15<sup>th</sup> October 2018

**Re: Application FP/195/18/PL – 2 Second Avenue, Felpham  
Proposed 4 bedroom house**

## PROPOSED STREET ELEVATION

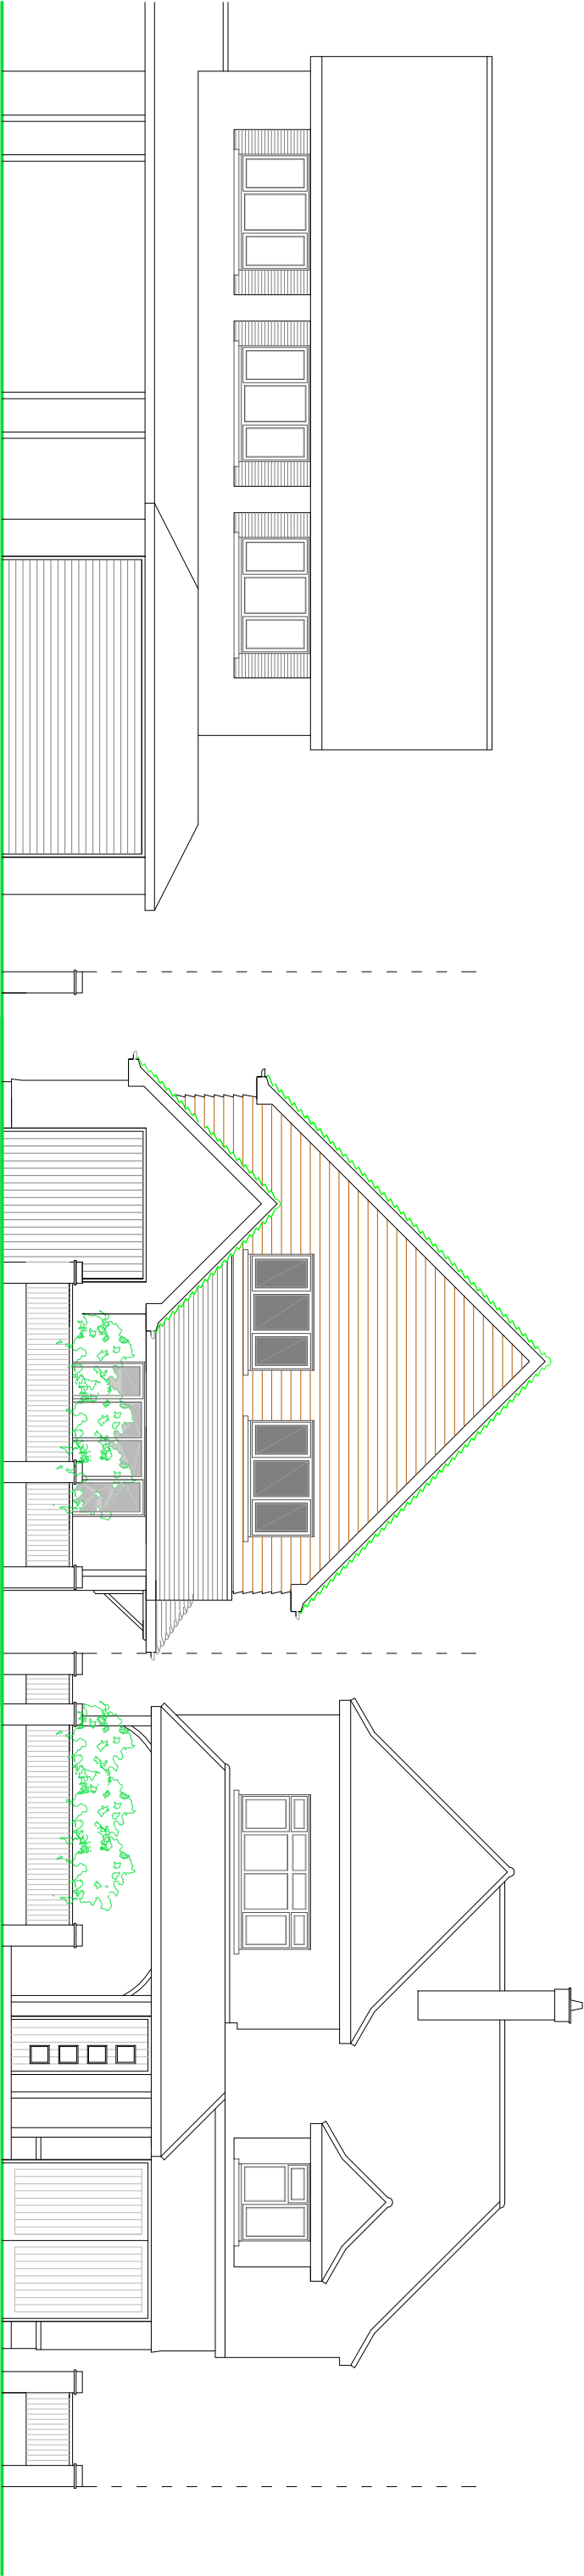
I am surprised that this professionally prepared application repeats an inaccurate plan, as did the 2007/8 and 2017/8 Application. This is potentially misleading as it misrepresents the adjacent house to the south, Shergar, which has a side extension which is not shown. This omission implies a greater sense of space than exists. This error was said by Arun to have been corrected in the previous application. It has not been corrected. We ask why this has not been noticed?
